**From:** Brenda Larsen  
**Sent:** Thursday, June 13, 2013 11:45 AM  
**To:** Jeff Watson  
**Subject:** RE: BL-13-00001 Seaton

Re: Seaton (BL-13-00001)

After conducting a review of the above named project, I have the following comments:

PROPOSED

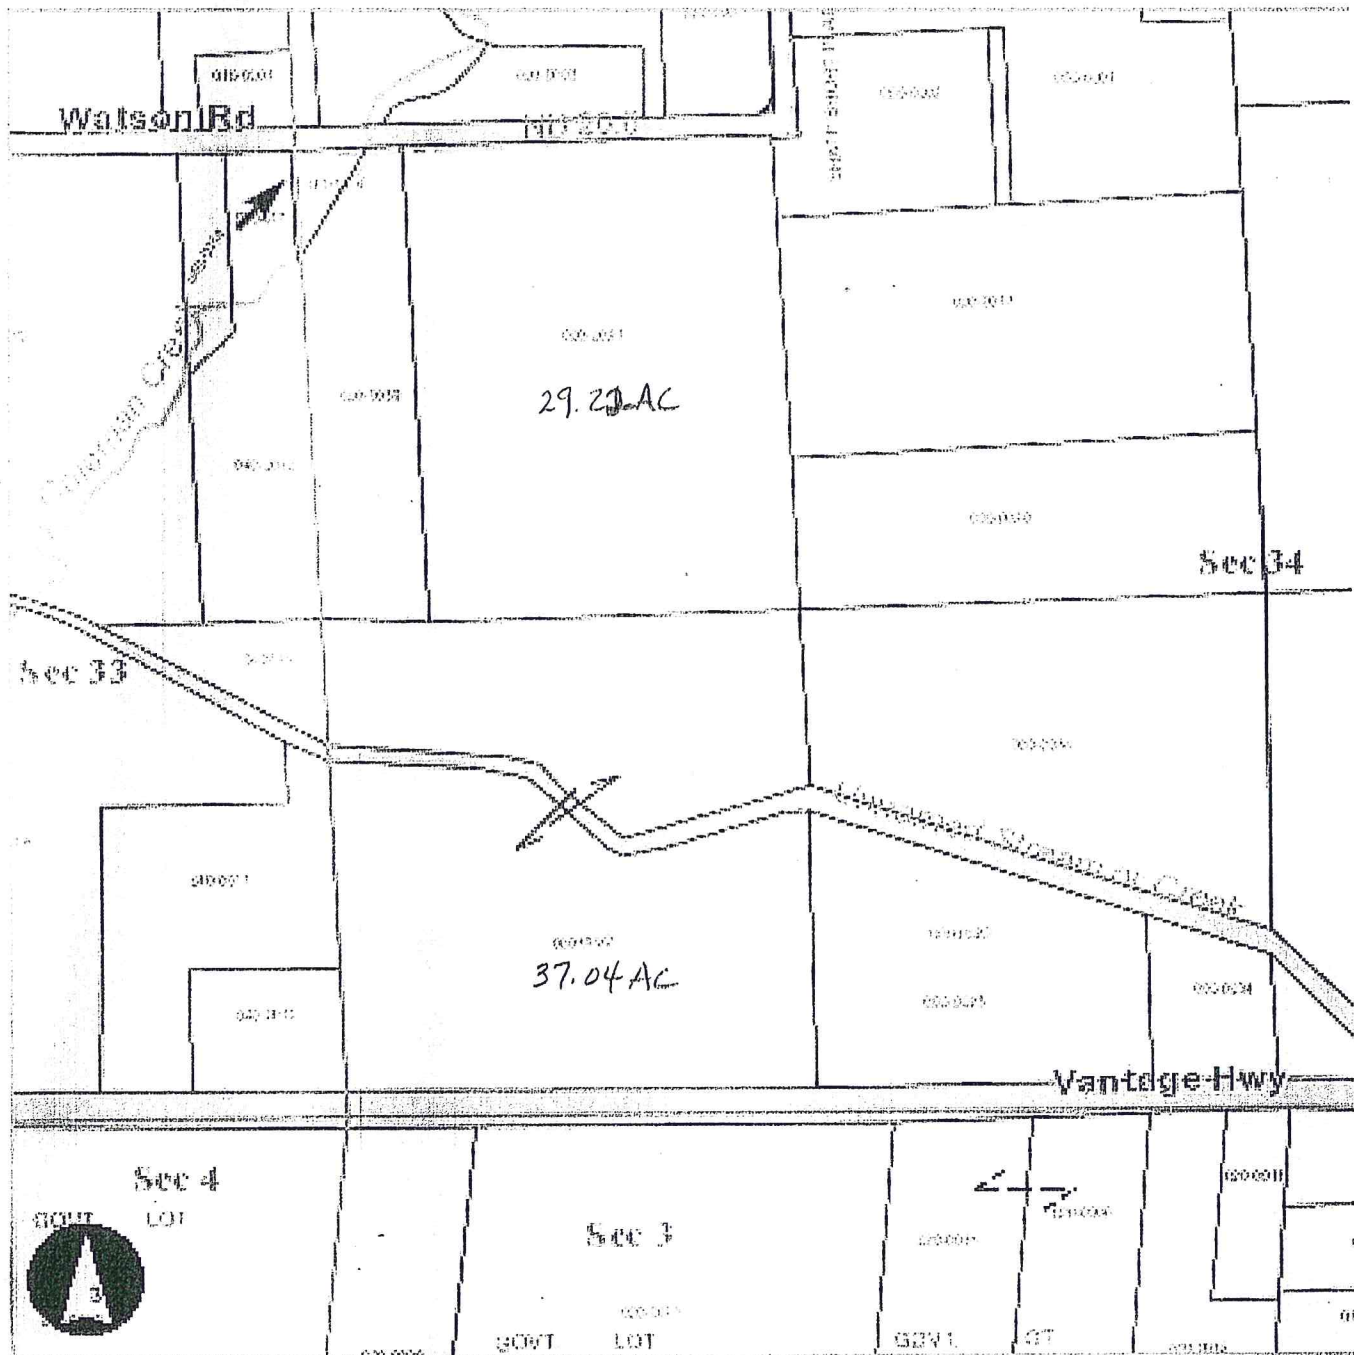
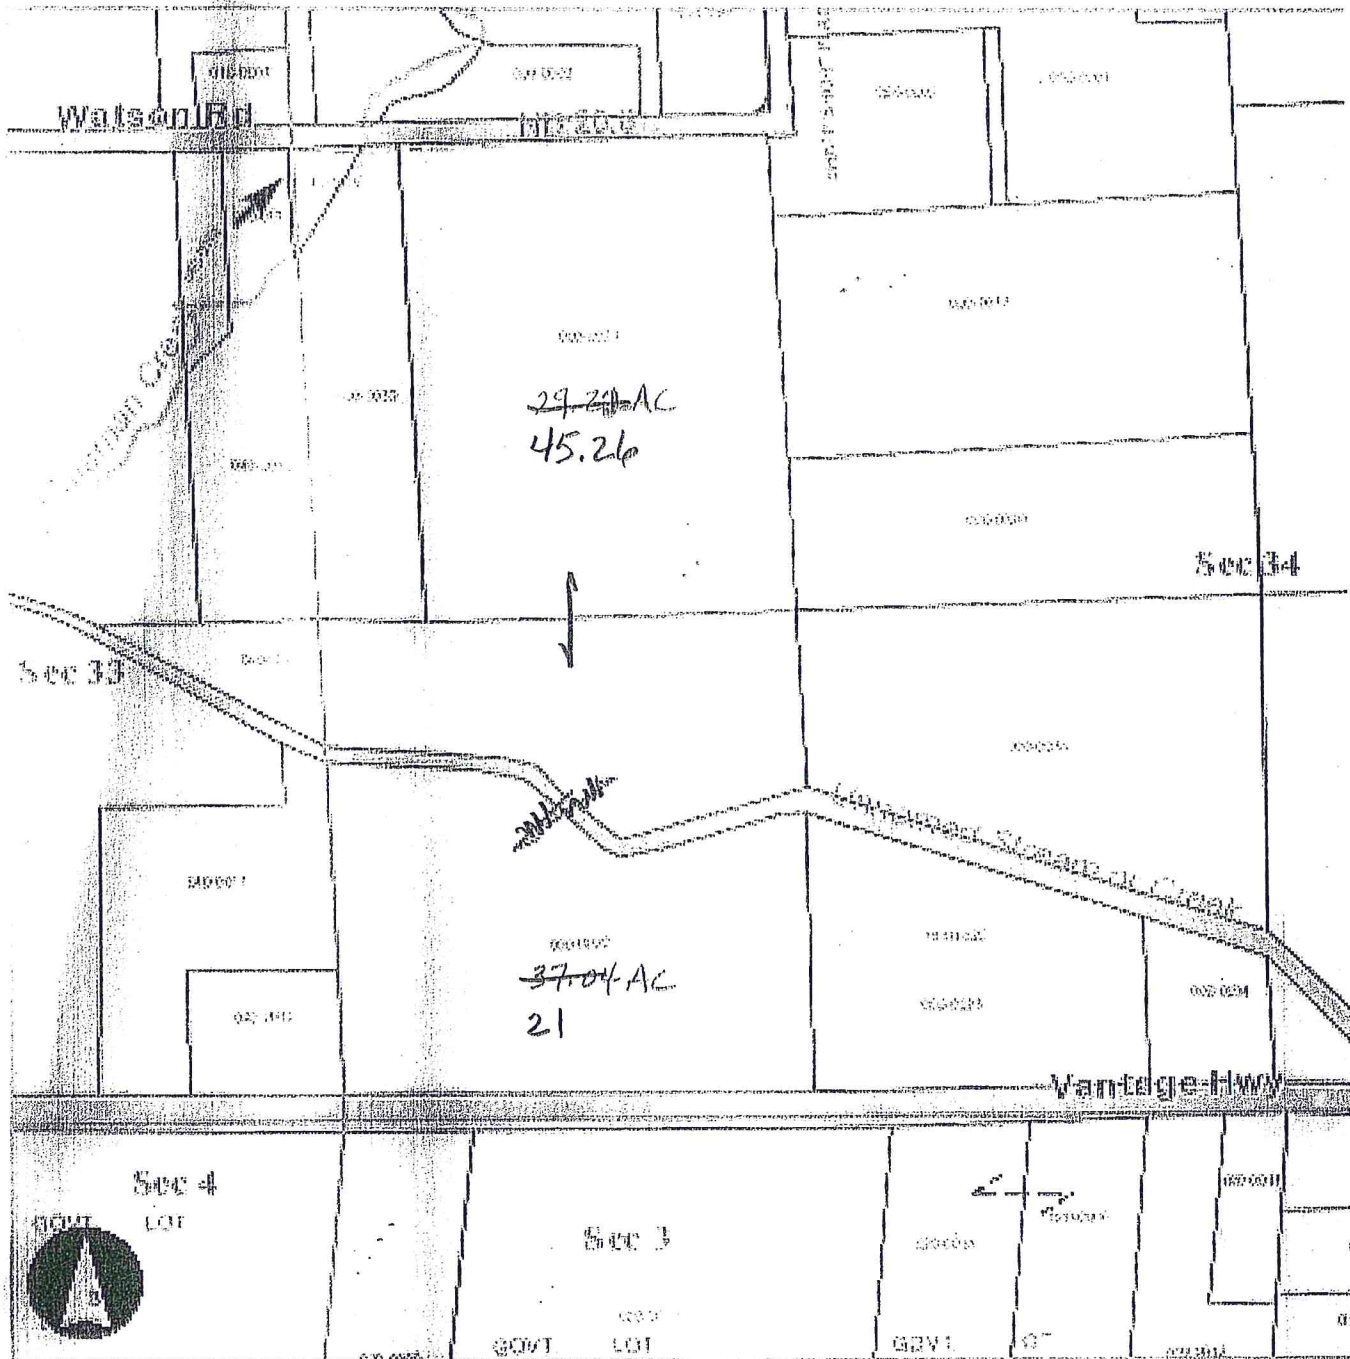
- Ensure that boundary line adjustments do not infringe upon existing structures, to include propane tanks, etc.
- Ensure adequate access for fire apparatus. Any driveways or access points created based off the new lot configurations shall comply with Kittitas County Code 20.02.030.
- All future development must comply with the International Fire Code.
